Addendum No. 1

RE: Contract # C204404

Cumberland County (U-4405A)

US-401 FROM OLD RAEFORD RD TO EAST OF NC-162 (BUNCE RD)

# UTILITY CONSTRUCTION PLANS CUMBERLAND COUNTY

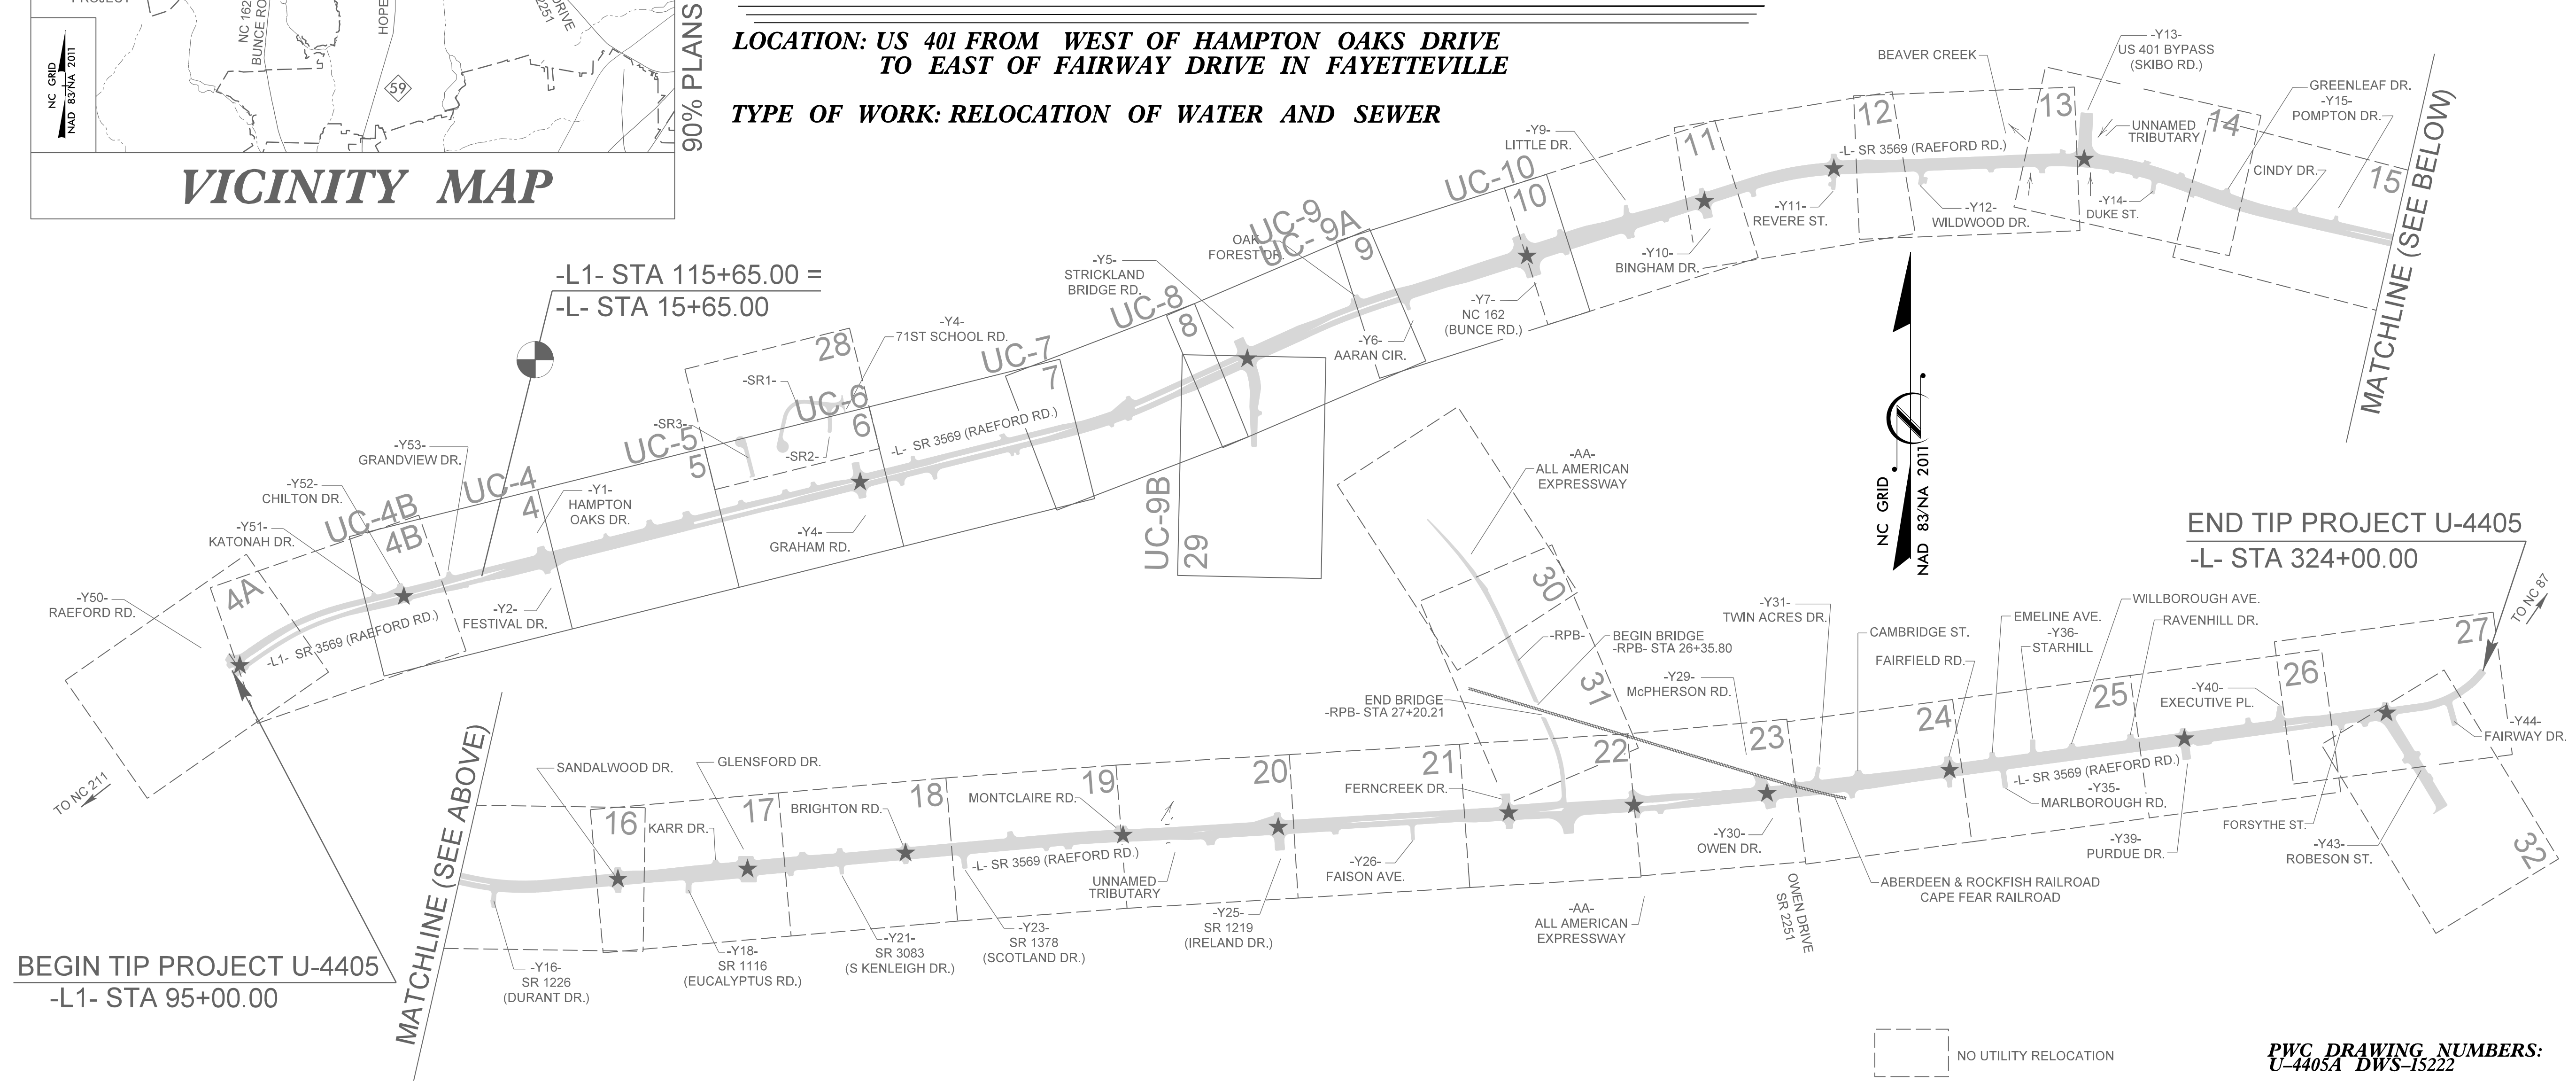
| Sheet No. | Revision |
|-----------|---|
| UC-1 | CHANGED UC-4A & UC-4B TO DASHED LINES SHOWING NO RELOCATION WORK ON THESE SHEETS. |

Drawing file: 280 UC Plans / 280_029_U4405A_ut_rdy4B_uc04B_psh.pdf

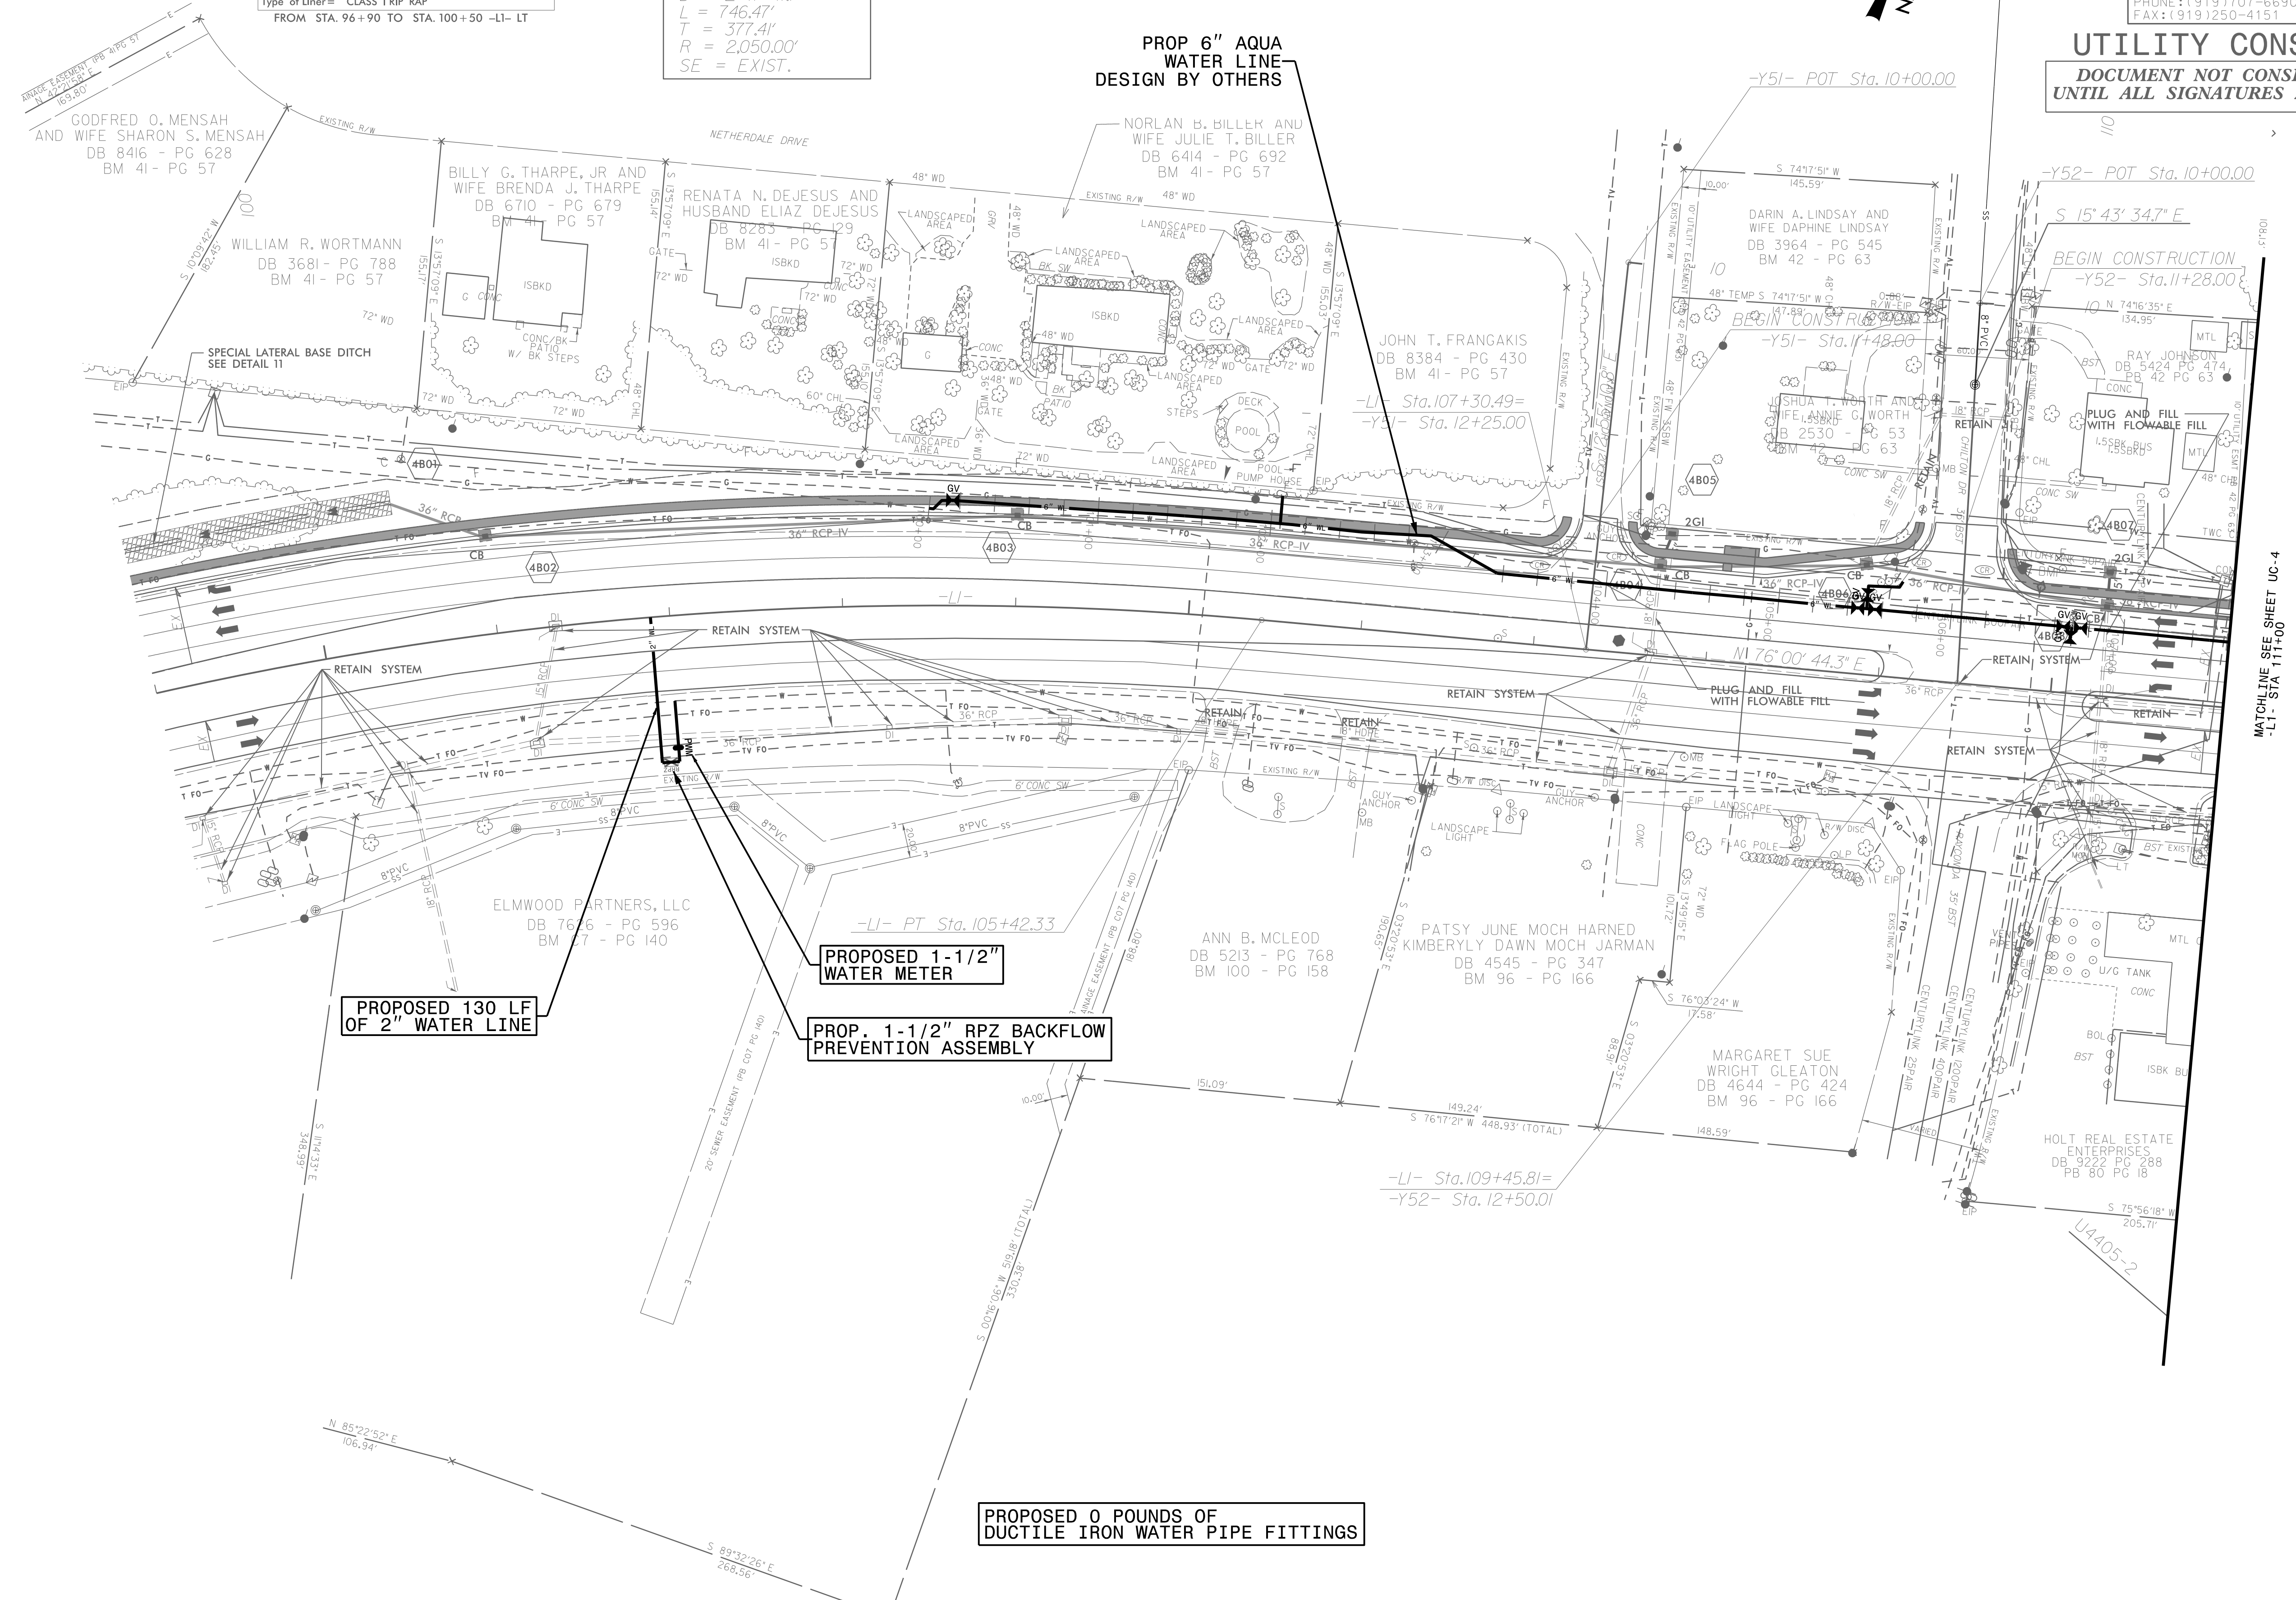
| Sheet No. | Revision |
|-----------------|---|
| UC-4B | DELETED |

Please void the above listed Sheets in your plans and staple the revised Sheets thereto. Remove Sheet UC-4B from your plan set.

Drawing file: 280 UC Plans / 280_043_U4405A_ut_rdy9_uc09A_psh.pdf

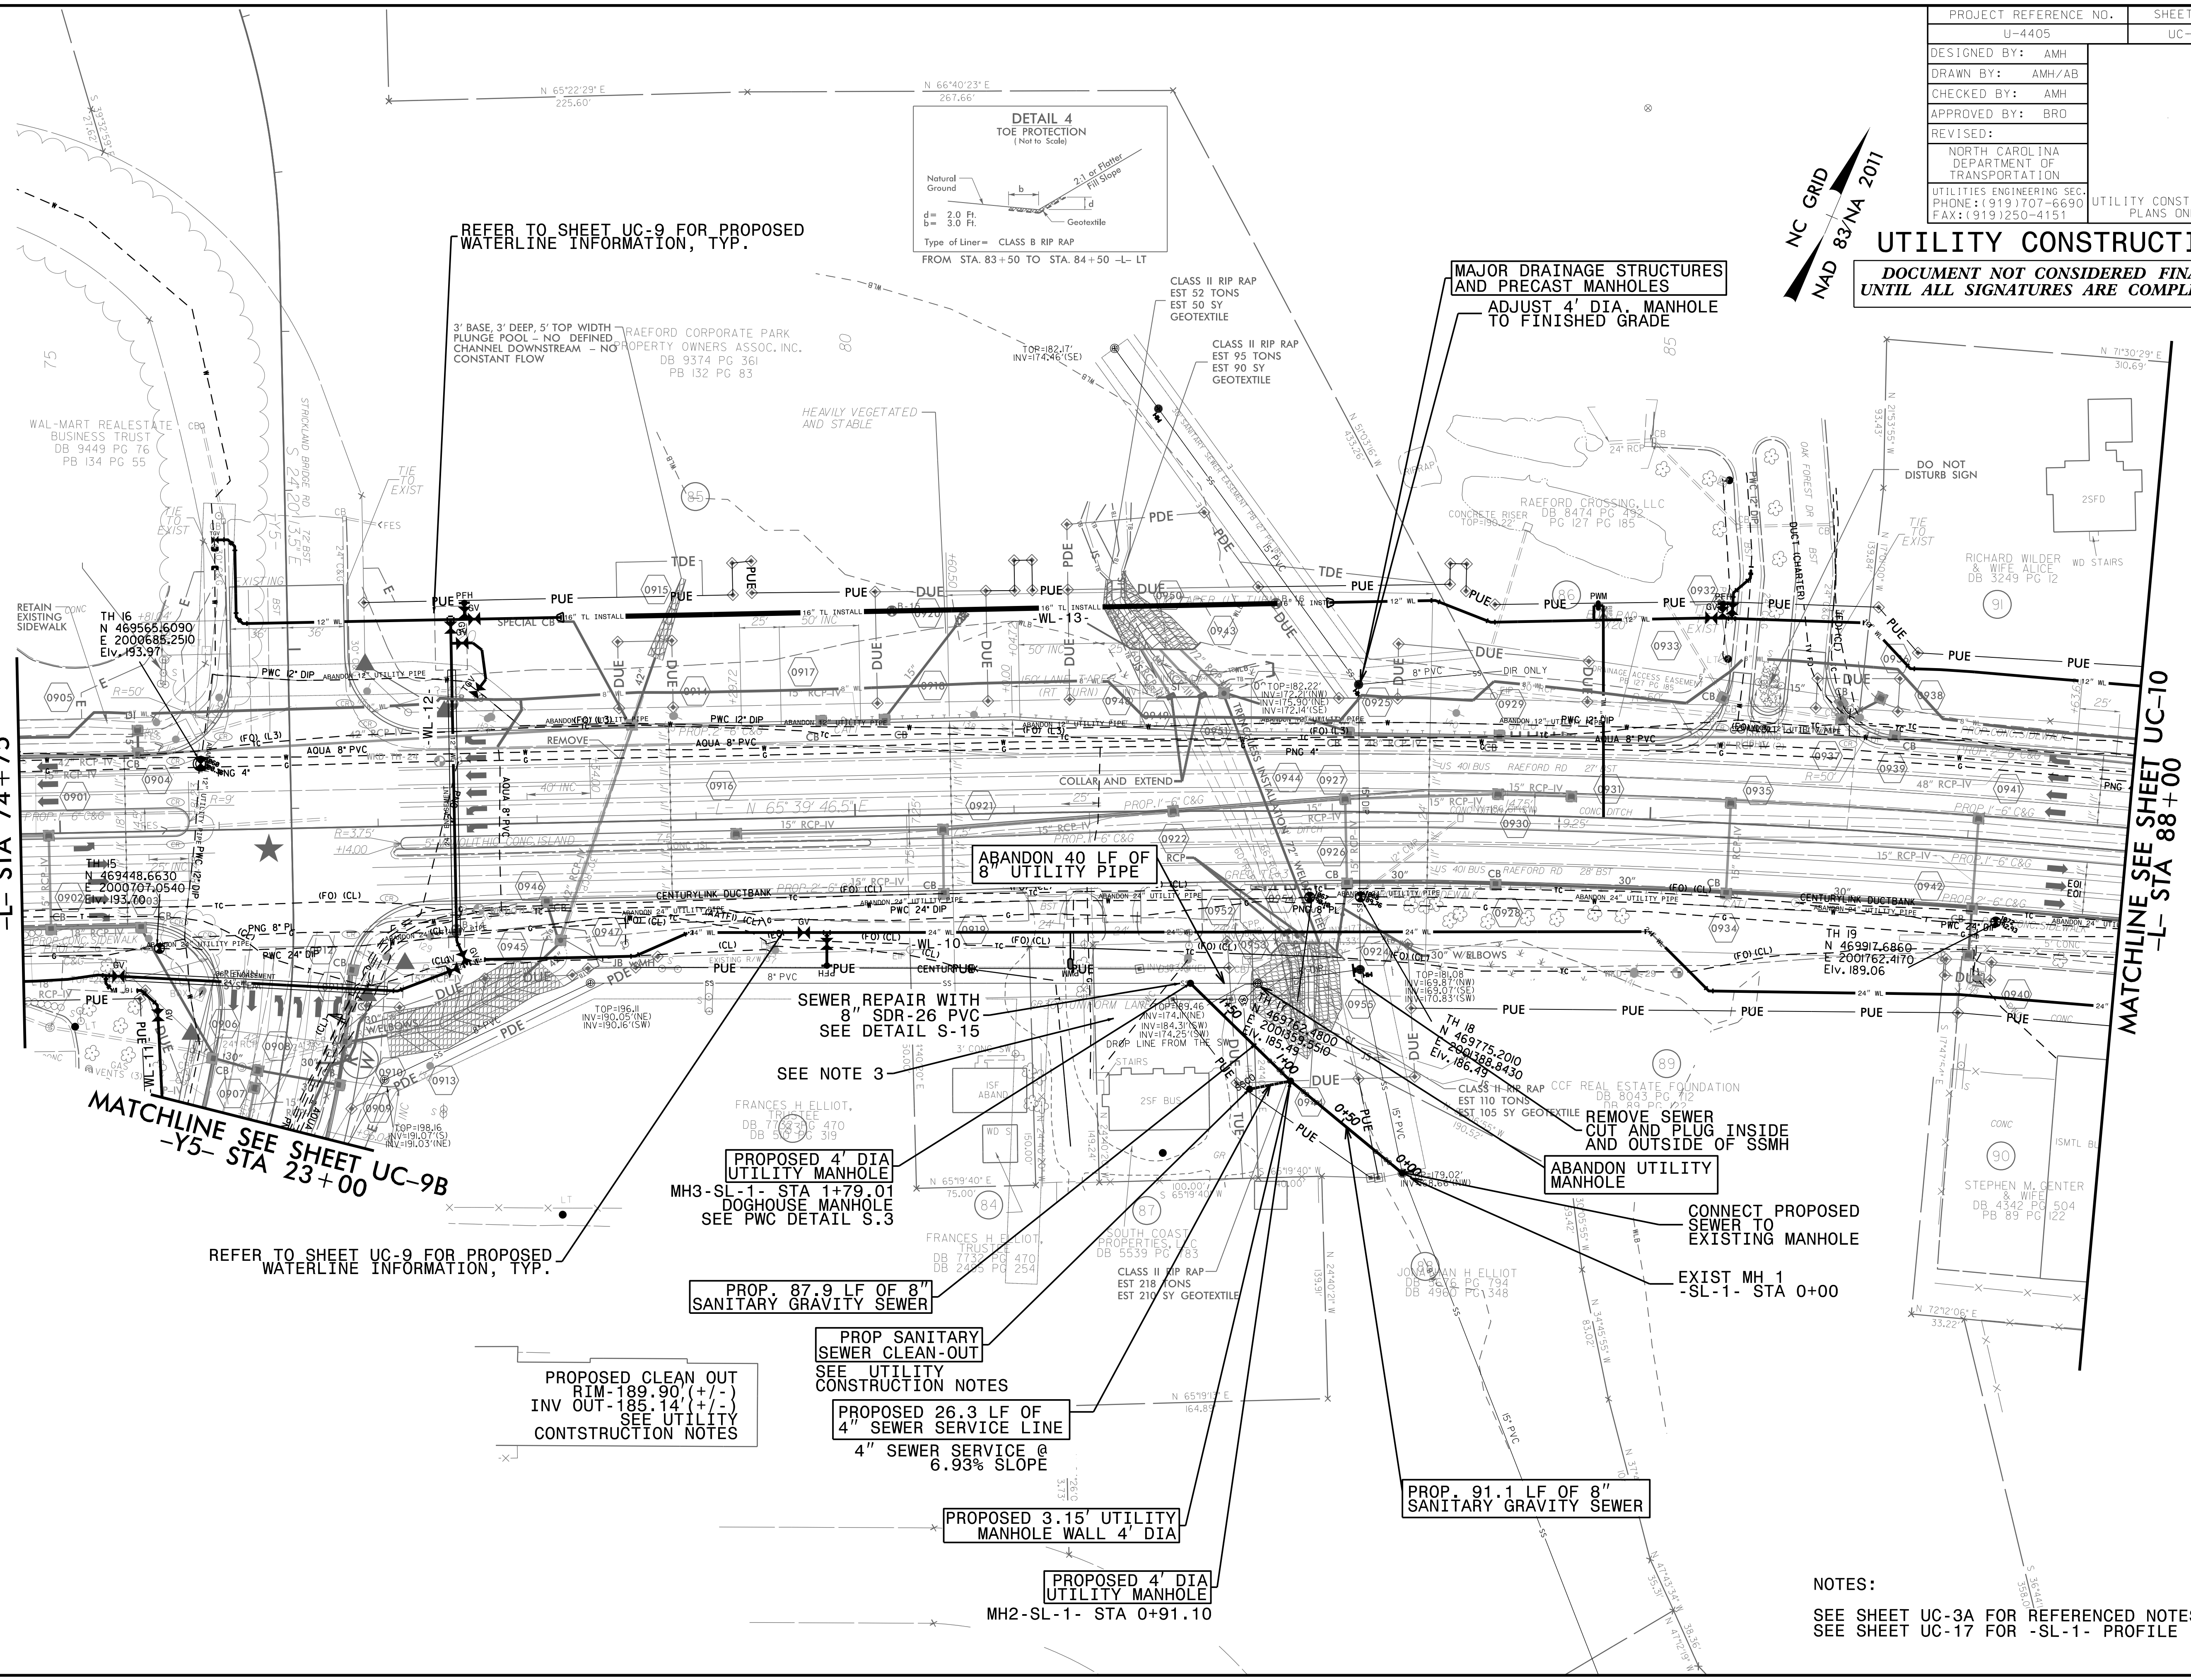
| Sheet No. | Revision |
|-----------------|---|
| UC-9A | MH3 CHANGED TO DOGHOUSE MH UPDATED LENGTH OF MANHOLE WALL FOR MH2 & MH3 REMOVED DROP STRUCTURE FOR MH2 REMOVED REFERENCE TO PIPE SLIDE AT MH3 & CONNECTION MH REMOVED CALLOUT REGARDING BYPASS PUMPING |
